NORTHAMPTON
GATEWAY
STRATEGIC RAIL FREIGHT INTERCHANGE

PARAMETERS PLAN – MINOR AMENDMENTS

DOCUMENT 8.15

PARAMETERS PLAN – MINOR AMENDMENTS | 26 FEBRUARY 2019

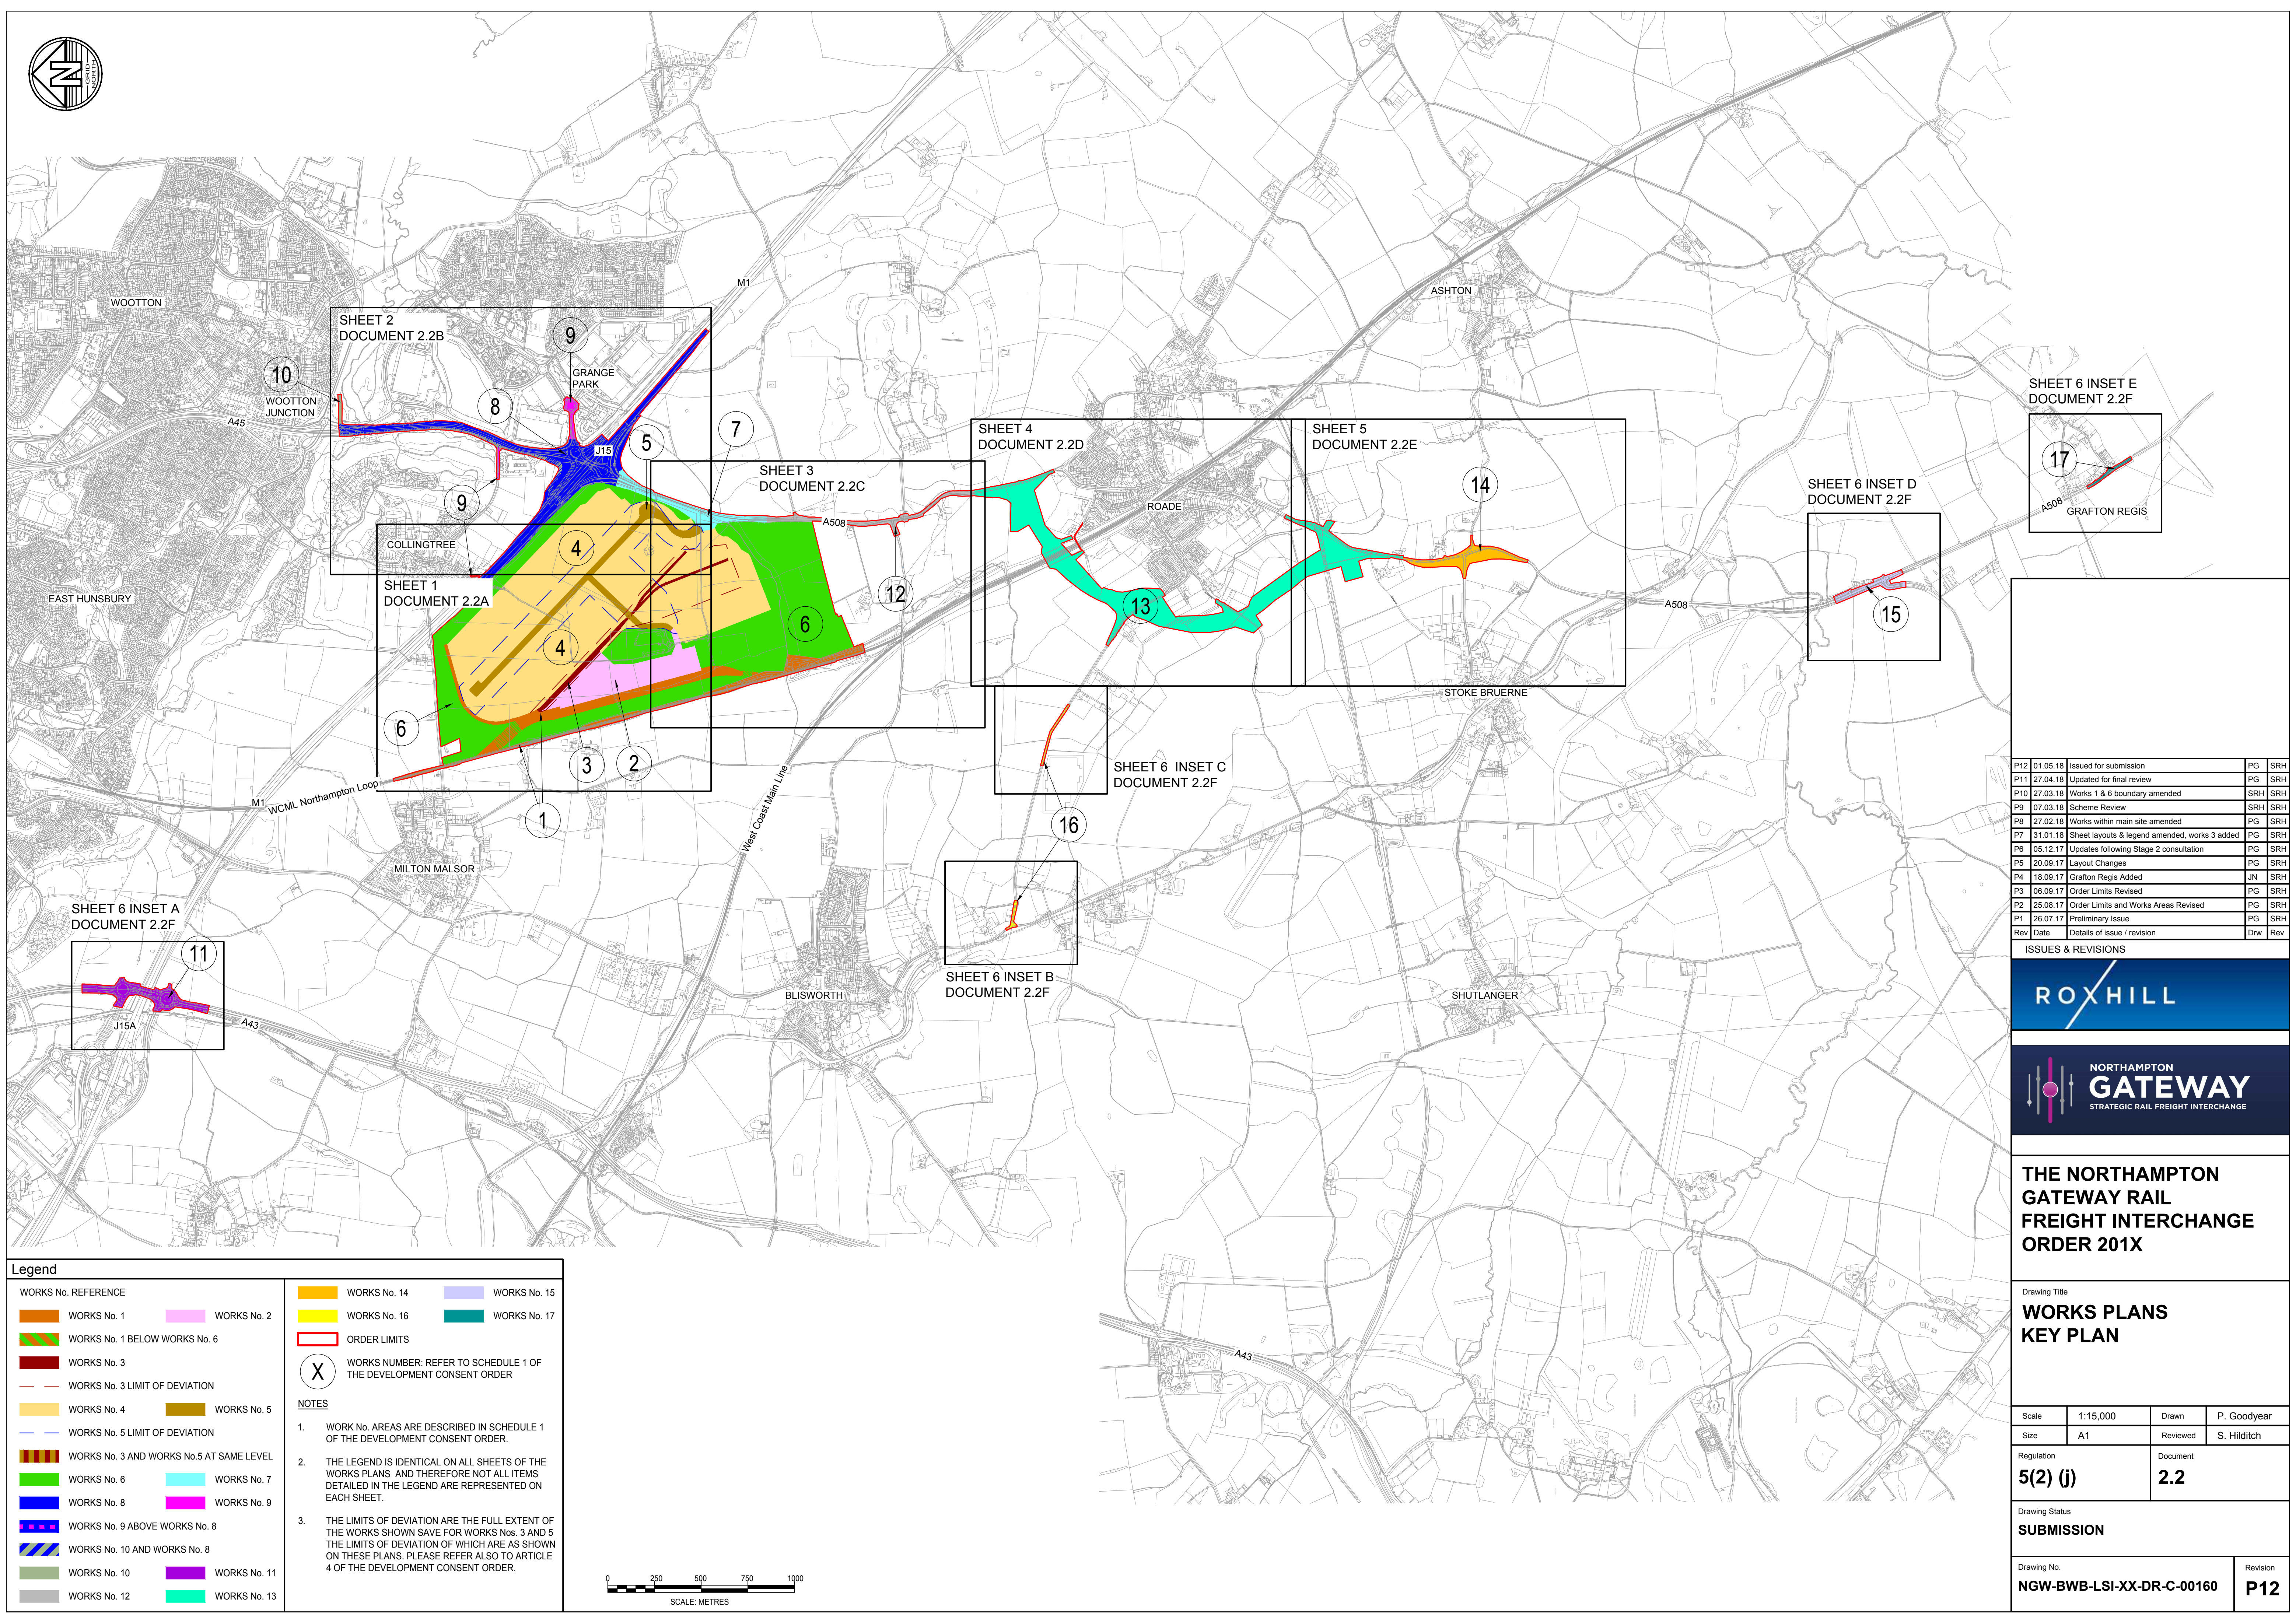
- 4.2 The change to the Parameters Plan relating to the rail access would require a consequential change to the area of Works No.1 , being the Works relating to rail infrastructure and, accordingly, revised Works Plans are also required, as follows:
- Works Plan Key Plan (**Document 2.2** Rev P13)
 - Works Plans Main Site Composite (**Document 2.2G** Rev P5).
 - Works Plans Sheet 1 (**Document 2.2A** Rev P10)
- 4.3 These plans are included in **Appendix 4** and are also submitted as separate documents for certification purposes.
